Our Ref: A/15/19/HH

**Town & Country Planning Act 1990 (as amended)
Town & country Planning (Development Management Procedure) (England) Order 2015
Application for Planning Permission for Works or Extension to a Dwelling**

Development Construction of an attached timber framed garden room at the rear elevation of the existing property
Location 2 Nanson Lane Angmering

Location, site & block plan
Date / Revision:
01/02/2019
Drawn by
LAG
Checked by
Checker
Scale: As indicated @ A2
PL001

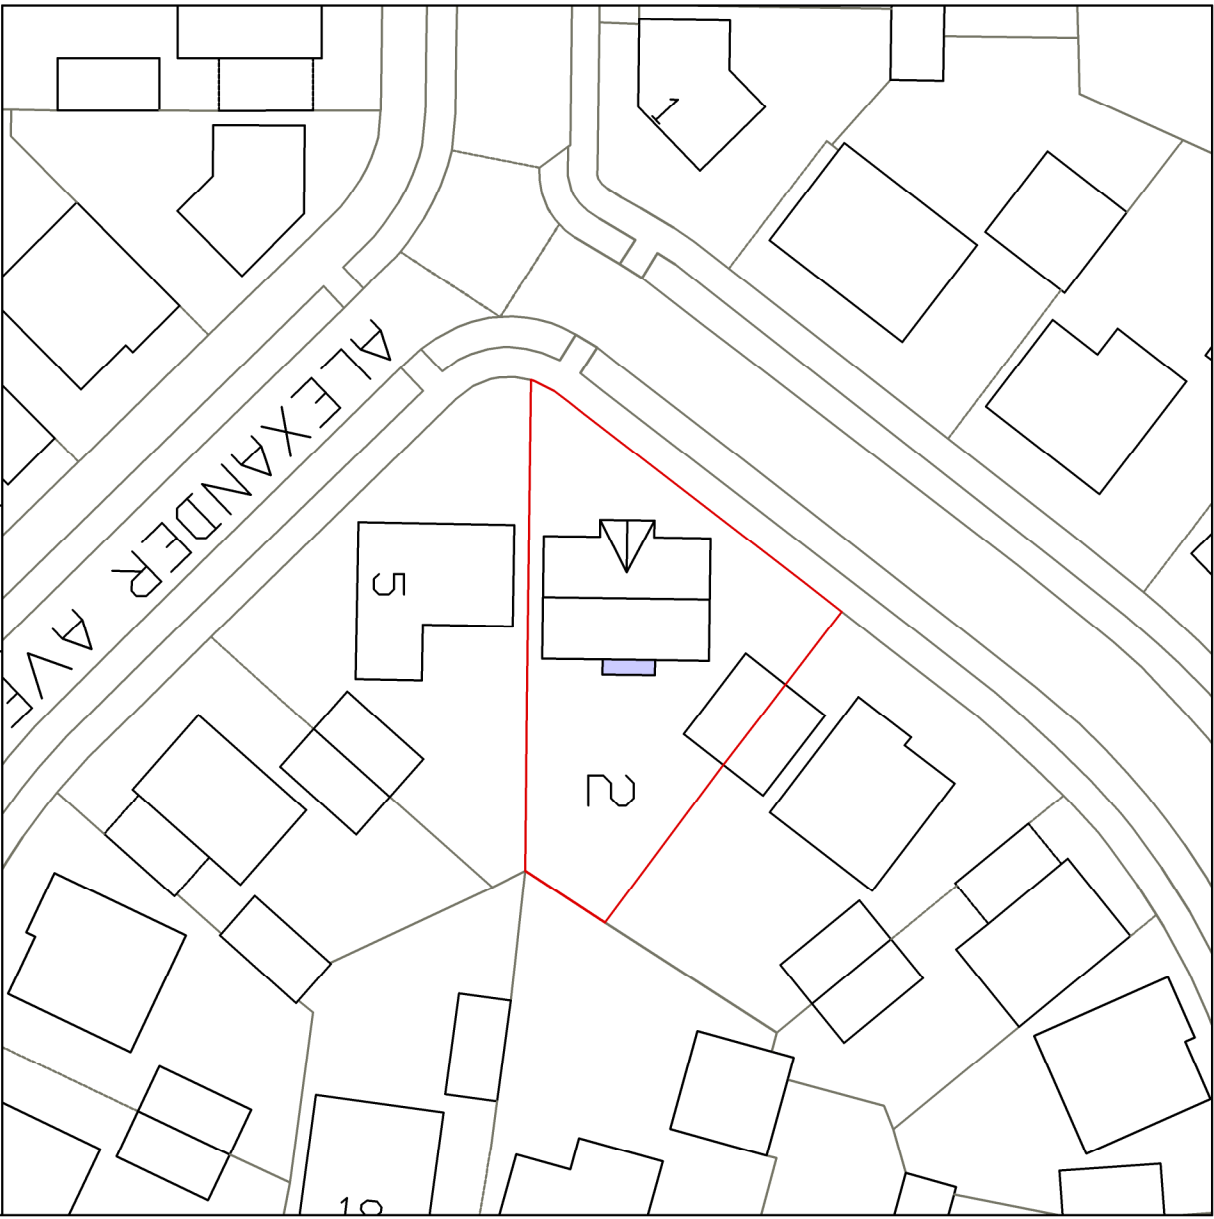
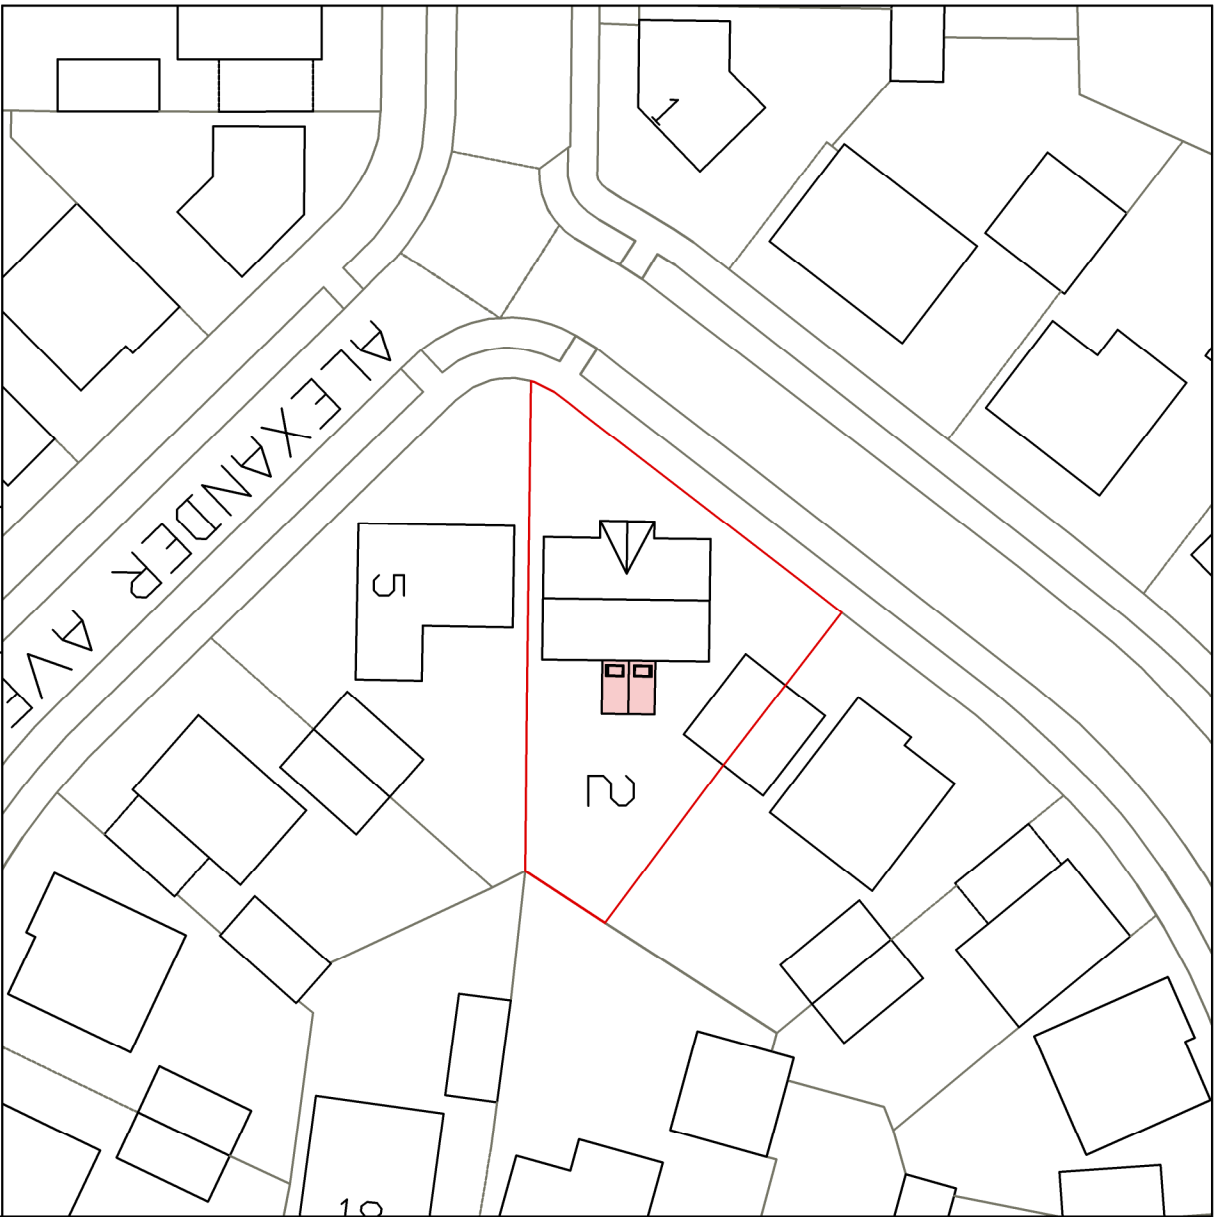
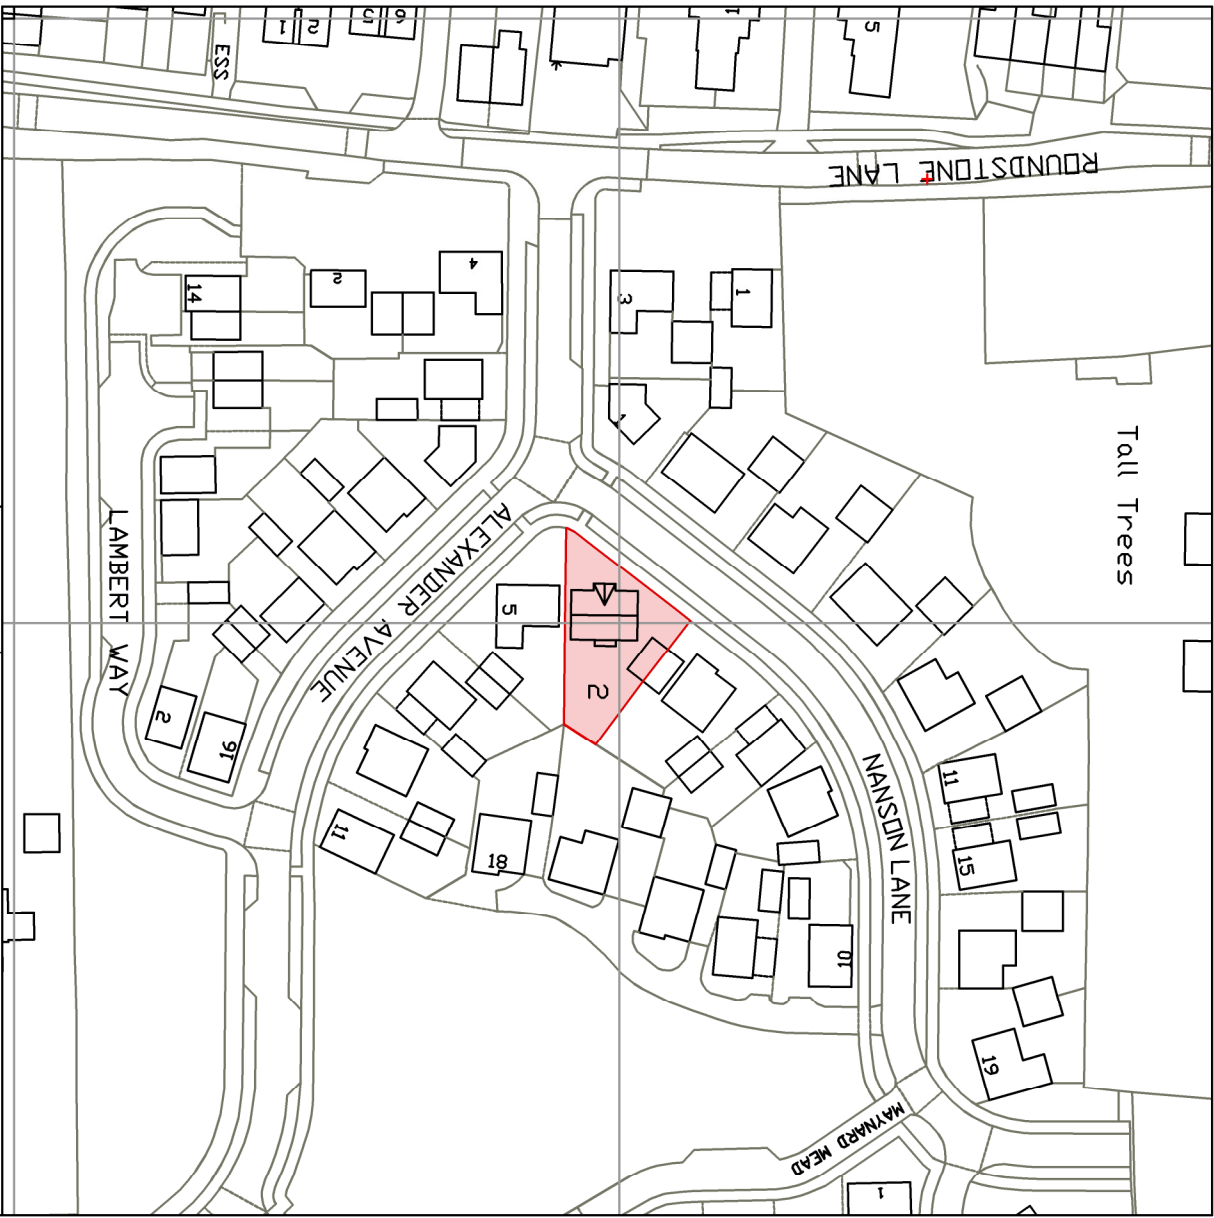
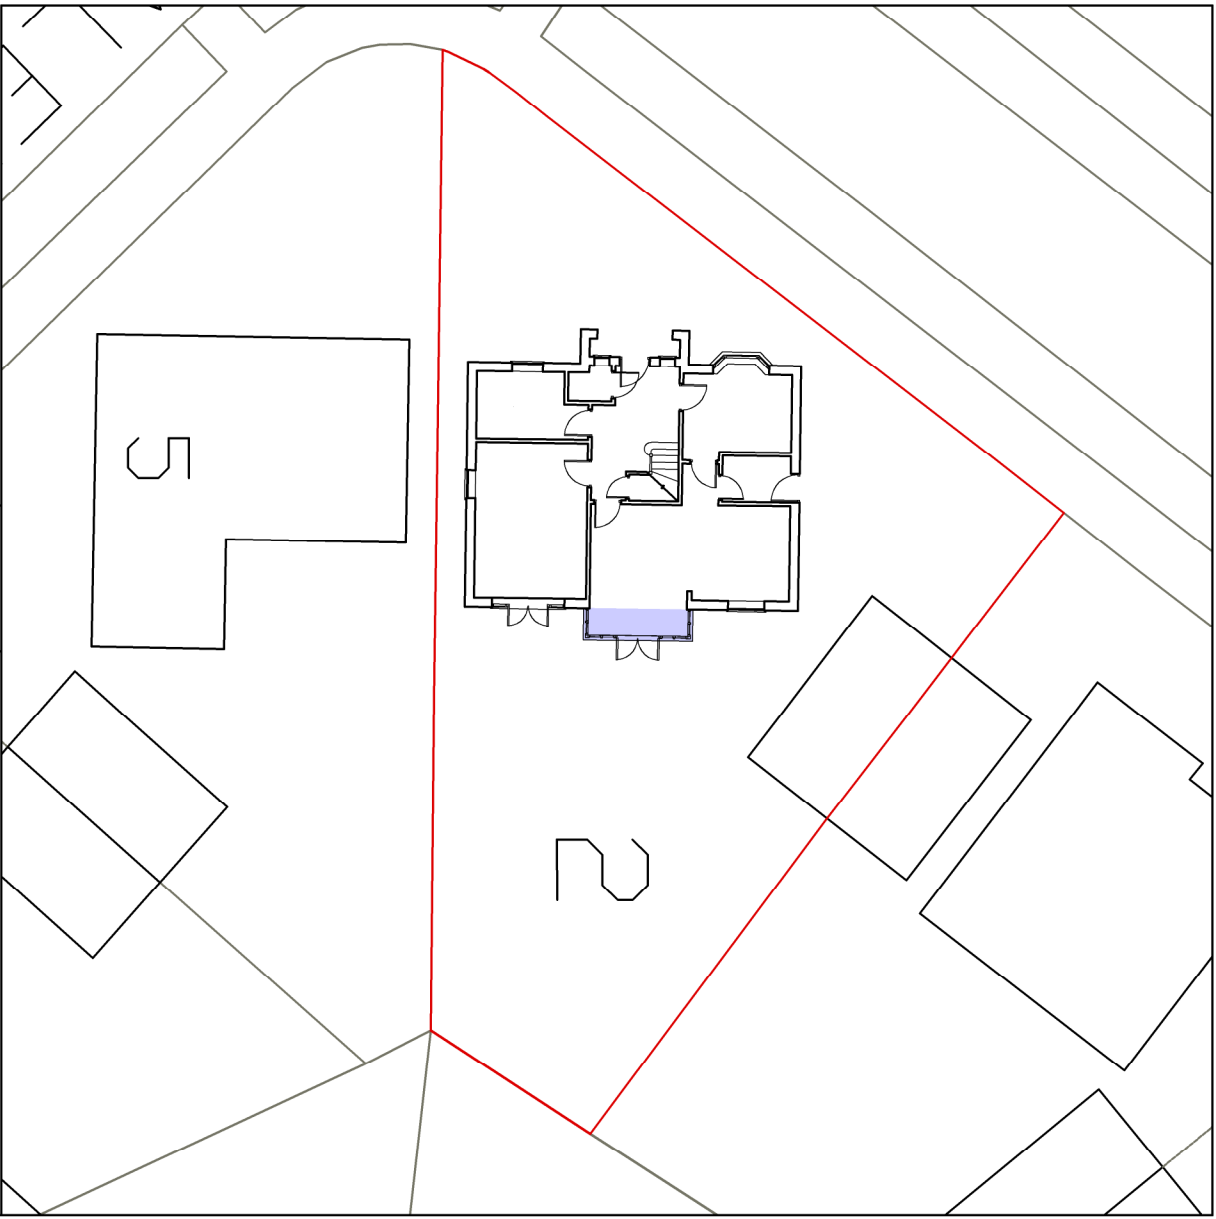
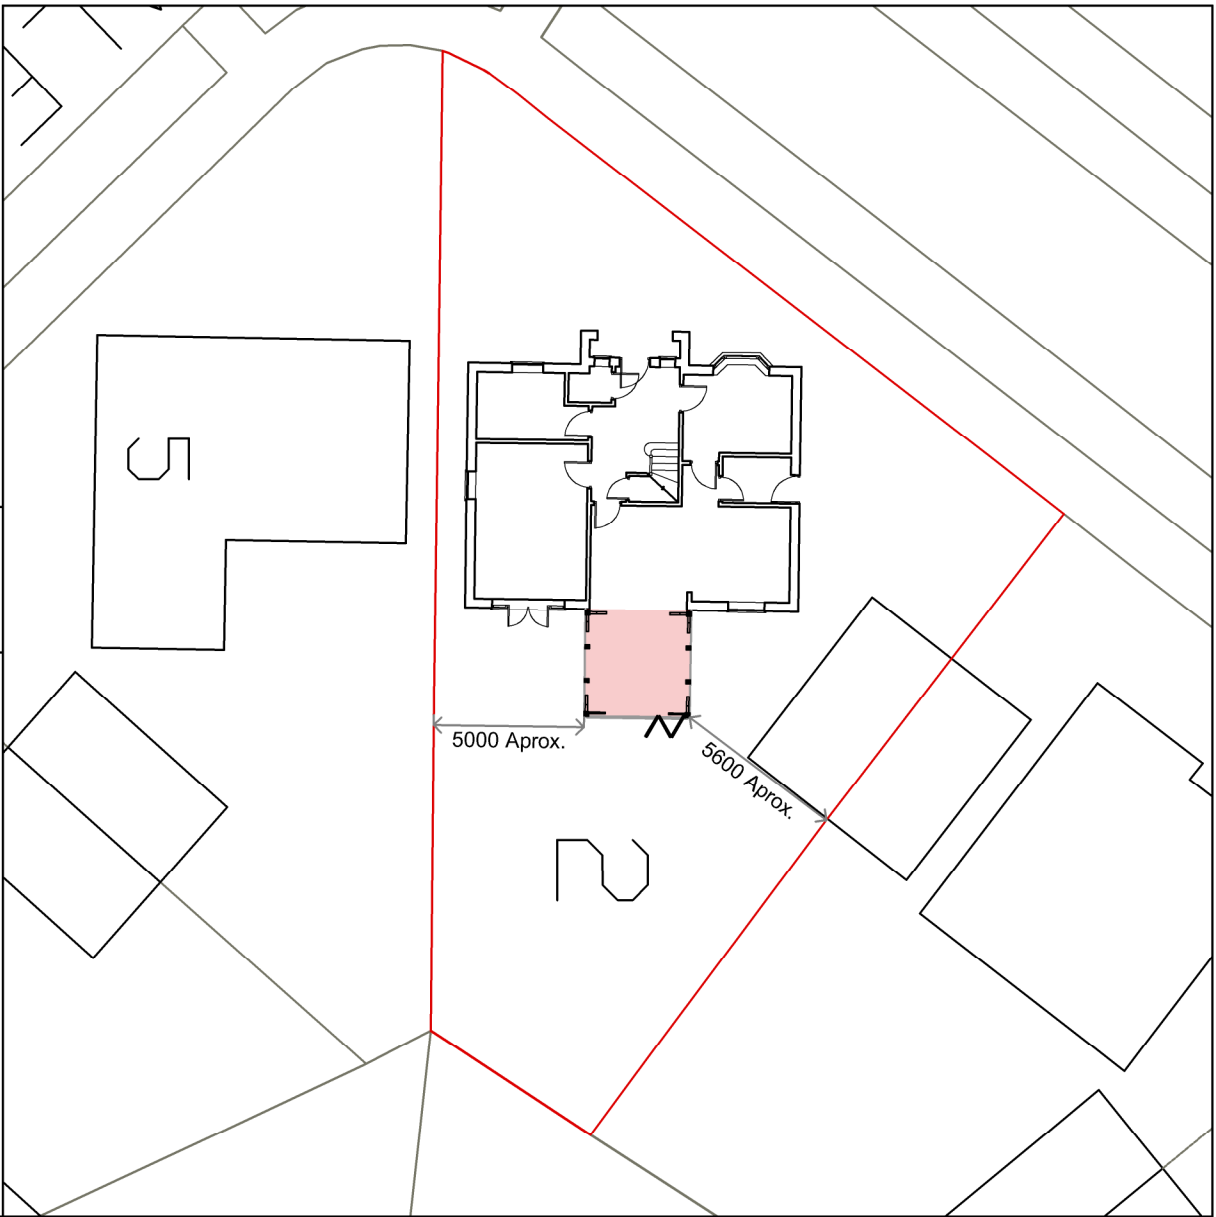
Block Plan

Please submit 1 electronic or 3 paper copies of a block/site which includes all dimensions from the proposed extension(s) to the site boundaries. Further details of what must be included on the plan can be found in the National Validation Requirements.

Label Incorrect: The site plan (2nd in) is labelled incorrectly as existing when it is showing the proposal. Please amend to proposed.
